Sea Link

Document 7.4.9: ~~Draft~~ Statement of Common Ground Between National Grid Electricity Transmission and the Harwich Haven Authority.

Planning Inspectorate Reference: EN020026

Version: ~~DC~~
~~April~~~~March~~ 2026

DRAWING TITLE:
NIP Concurrent Activity Areas

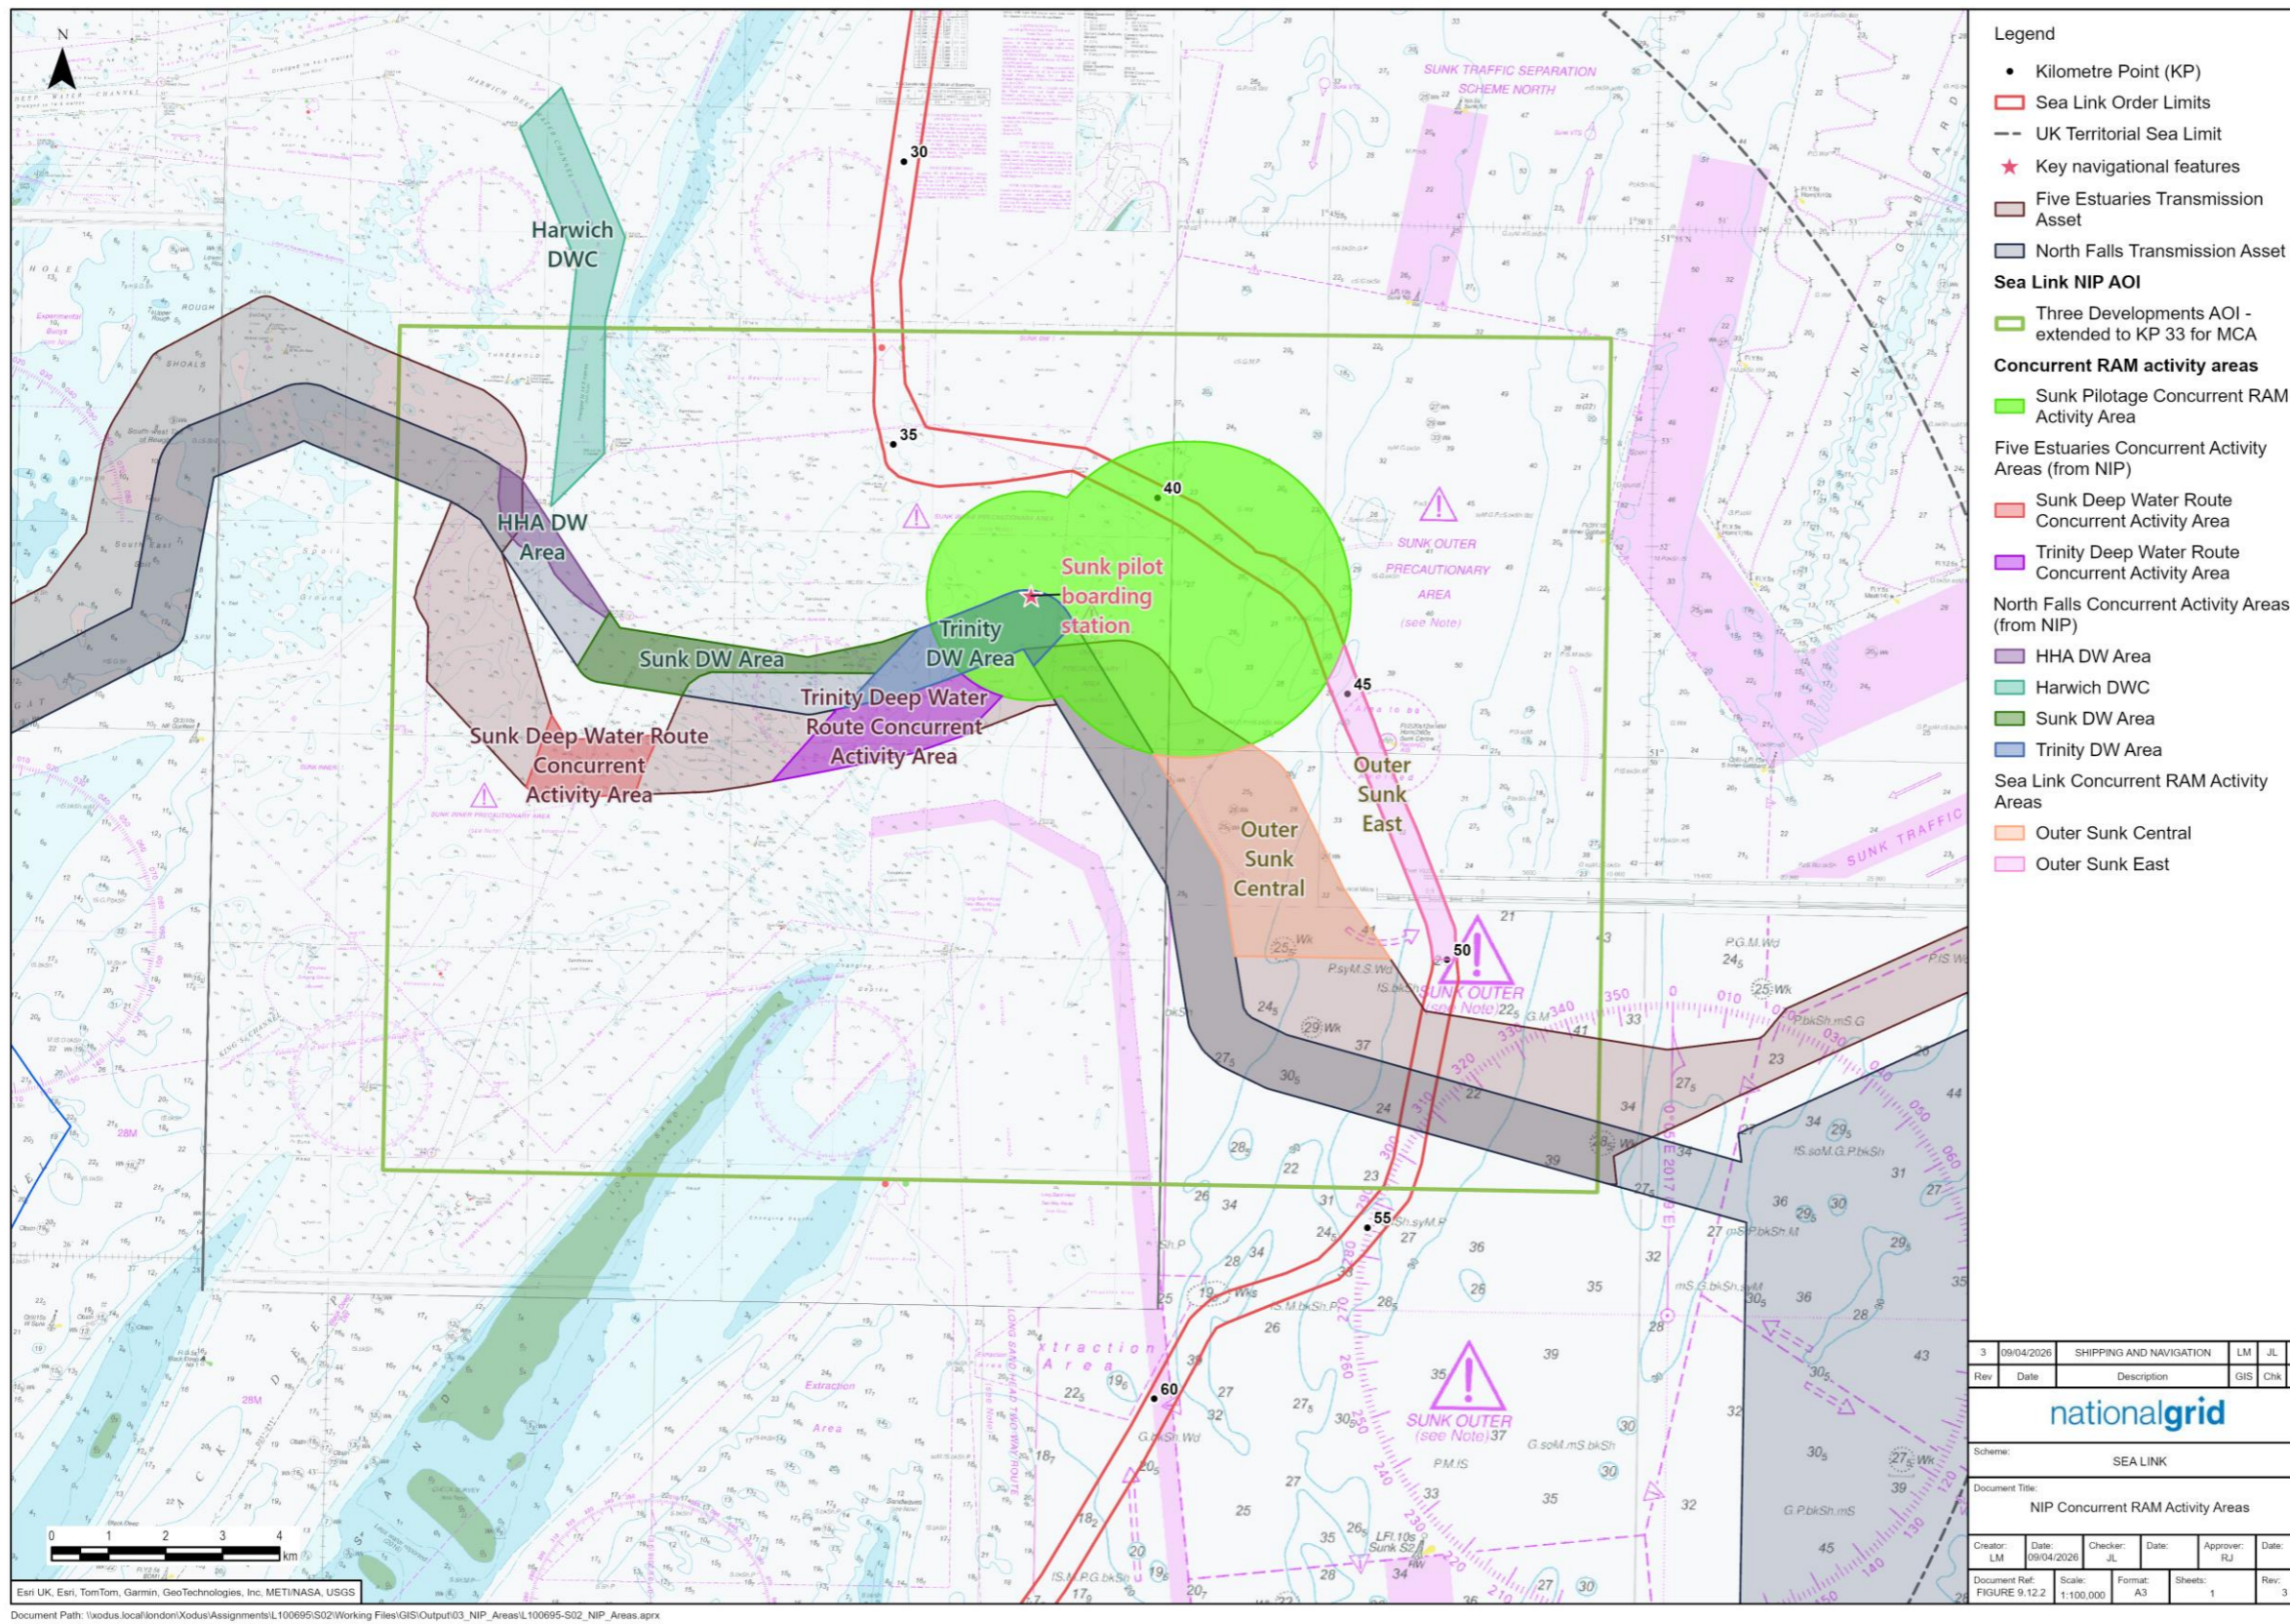
3.2.2	Application Document 6.2.4.7 (C) Part 4 Marine Chapter 7 Shipping and Navigation [REP4-035].	Scheduling	<p>The Consultee requests that no works conducted as part of the Proposed Project should run concurrently with works already planned by Five Estuaries and North Falls project operators in the area, as it is their opinion that this would cause an unacceptable level of navigation risk.</p> <p>The Consultee requests that no Restricted Ability to Manoeuvre (RAM) works conducted by the Proposed Project should run concurrently with RAM works already planned by the Five Estuaries and North Falls project developers in the Sunk area (or other future projects). It is the Consultee's opinion that this would cause an unacceptable level of navigational risk. Therefore, the Consultee insists that the Sea Link project liaise with other planned project teams and the Consultee to avoid this situation. This requirement for no RAM concurrent works, operations or activity must be written into the DCO.</p> <p>Concurrent RAM construction activity / SIMOPS in the Sunk area (highlighted green on the below chart section) has not been assessed the developer's navigation risk assessment. We do not consider the overt risk from more than one RAM operation in the defined area to be ALARP.</p> <p>If necessary, a first come first serve policy for RAM works will have to be instigated, although combined planning by the developers should avoid the need for this.</p> <p><u>The Consultee highlights that the green area on the image below was agreed in a meeting with the ports, MCA and Trinity House and the Applicant, Five Estuaries and North Falls. This area is the crucial area for HHA for no concurrent RAM operations.</u></p>	<p>The Applicant agrees with the Consultee that simultaneous operations (SIMOPS) between different projects undertaking RAM works would be undesirable <u>is a risk that must be (and is being) mitigated.</u> The Applicant <u>can confirm ongoing will</u> consultation with the other projects on timescales and <u>will</u> keep all of its marine stakeholders informed on any potential interactions. These mitigations are captured within Application Document 6.2.4.7 (C) Part 4 Marine Chapter 7 Shipping and Navigation [REP4-035].</p> <p>The Applicant confirms that the Navigational Installation Plan (NIP) is the most appropriate place to secure concurrent RAM operations. This also aligns with the approach taken in the Five Estuaries and North Falls DCO applications.</p> <p>The Applicant has produced a communication protocol in the form of a Navigation Installation Plan (NIP) to address this need for communication of construction details and enable collaboration with other offshore developments. The NIP establishes the plan for communication throughout key project phases, in particular the construction phase. This is noted in Application Document 6.2.4.7 (C) Part 4 Marine Chapter 7 Shipping and Navigation [REP4-035].</p> <p>The NIP also establishes the 'Concurrent Activity Area' within which such RAM SIMOPS restrictions would apply. The Applicant submitted a draft Outline NIP to PINS on 1 September 2025, as part of the Application Document - Applicant's response to the ExA's s89(3) letter 8 July 2025 & 5 August 2025 – 9.12 Outline Navigation and Installation Plan [AS-104].</p> <p>Further to the above, the Applicant confirms that an update to Application Document 9.12 (B) Outline Navigation and Installation Plan [REP4-076] was submitted at Deadline 4 which is secured within the deemed Marine Licence (dML) under</p>	Agreed Not Agreed <u>Under discussion</u>

Ref	Relevant Application Document	Summary of Description of Matter	HHA Current Position	The Applicant's Current Position	Status
			<p><u>The Consultee clarifies that they wish the matter of concurrent RAM activities to be secured within the dML as a Requirement.</u></p>	<p>Condition 4 <u>in which the outline plan must substantially accord.- (g)-</u></p> <p>Condition 4-(g) of the dML requires the Navigation and Installation Plan to be submitted to and approved by the MMO before works can commence. This Plan needs to be in accordance with the outline Plan (which already features the commitment). Once submitted to and approved by the MMO it forms part of the licensed activities which are enforced by the existing and comprehensive regulatory regime under the Marine and Coastal Access Act 2009.</p> <p>This document secures the HHAs request that no Restricted Ability to Manoeuvre (RAM) works conducted by the Proposed Project should run concurrently with RAM works already planned by the Five Estuaries and North Falls project developers in the areas defined within Plate 3.1 of Application Document 9.12 (B) Outline Navigation and Installation Plan [REP4-076] and outlined as the green area in the figure below, <u>and as described in section 3.3 of Application Document 9.12 (D) Outline Navigation and Installation Plan, submitted at Deadline 7.</u></p> <p><u>With the above in mind, the Applicant has followed the same approach to securing Concurrent RAM Activities mechanisms as that agreed for the Five Estuaries and North Falls projects with regards to securing Concurrent RAM Activities.</u></p>
